From: Hugo, Bridey [REDACTED] >
Sent: Thursday, 19 December 2019 5:21 PM
To: Javier Canon
Subject: Yarrabee Solar Farm (SSD-9237-Mod-1) - Submission

Please find the following feedback from Narrandera Shire Council regarding the modification

Figure 17 Peak Hour Construction Traffic – Western Access Only

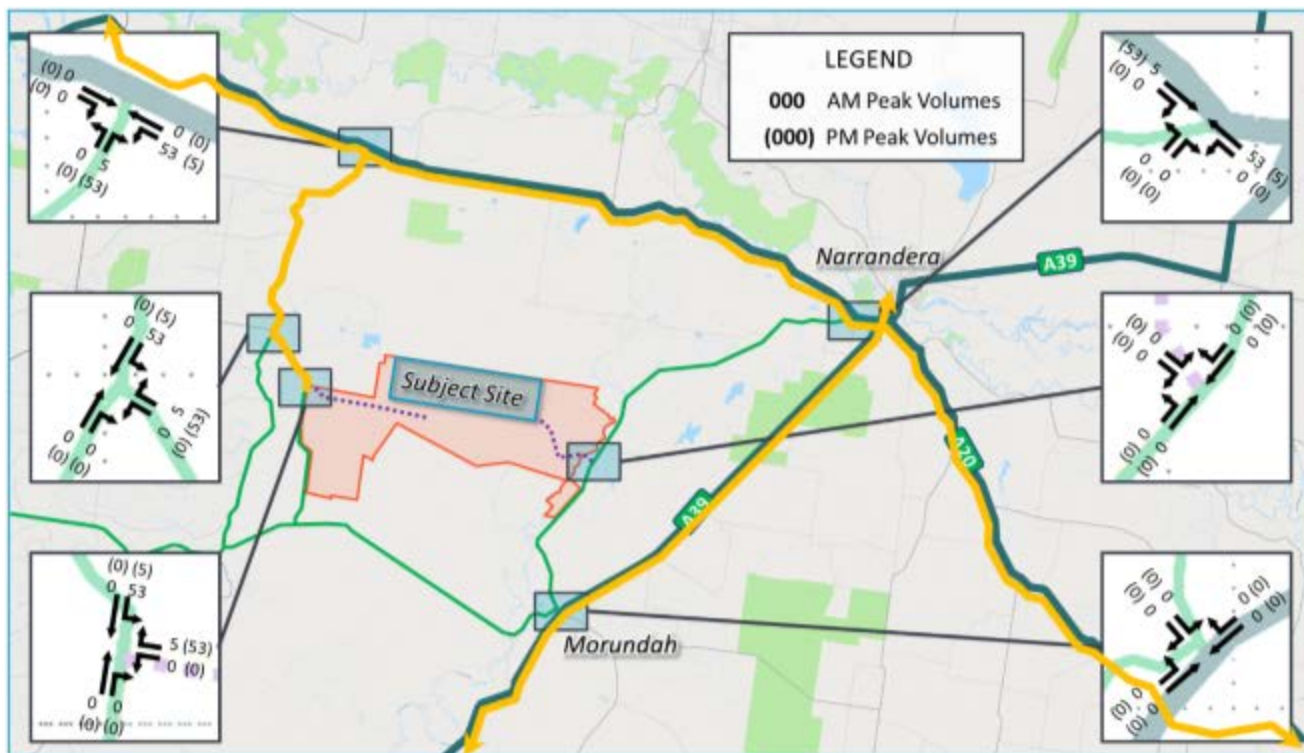
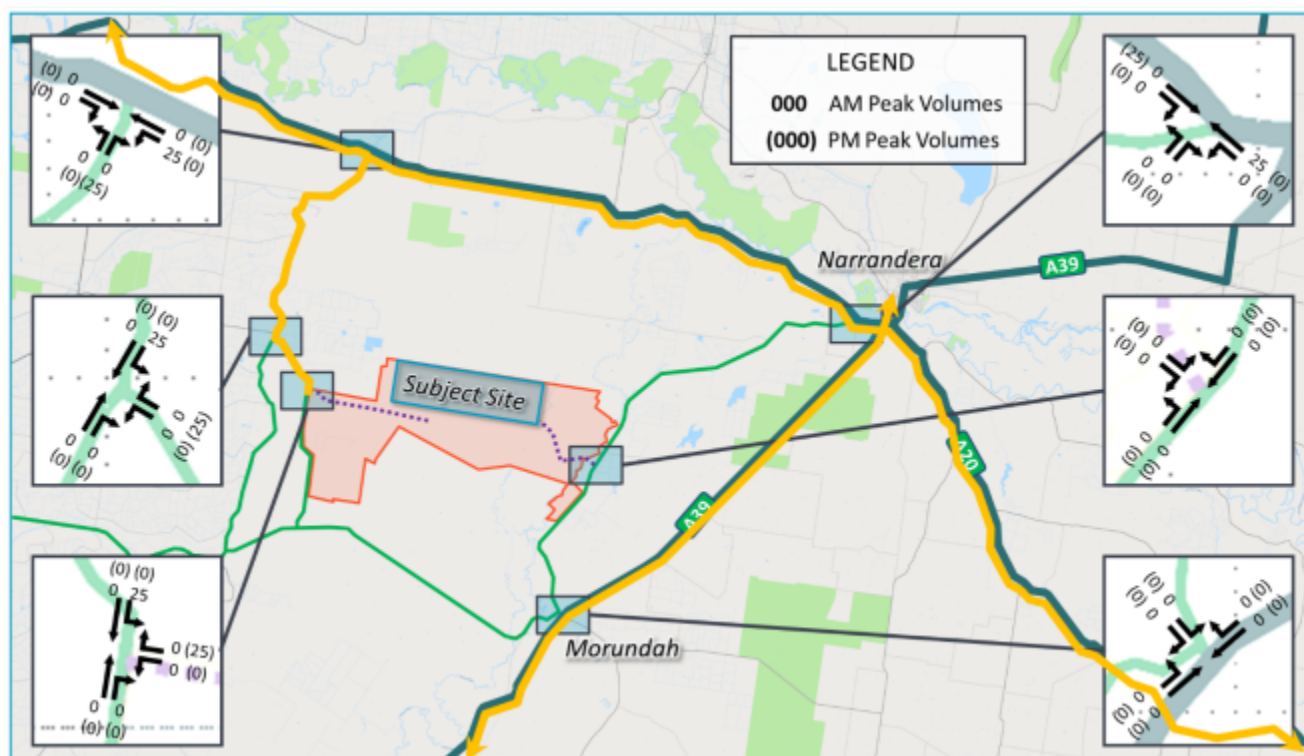
- Traffic Movements - NSC has no objection to construction and operation traffic being concentrated via the western access and the road/intersections conditions for this access would remain priority to the Murrumbidgee Shire. However NSC does have concerns that not all traffic, especially operation traffic, will still be significant from the east. Therefore it is our belief that the original conditions should remain in relation to the eastern access.
- BESS changes – Council has no comment to make regarding the these changes.
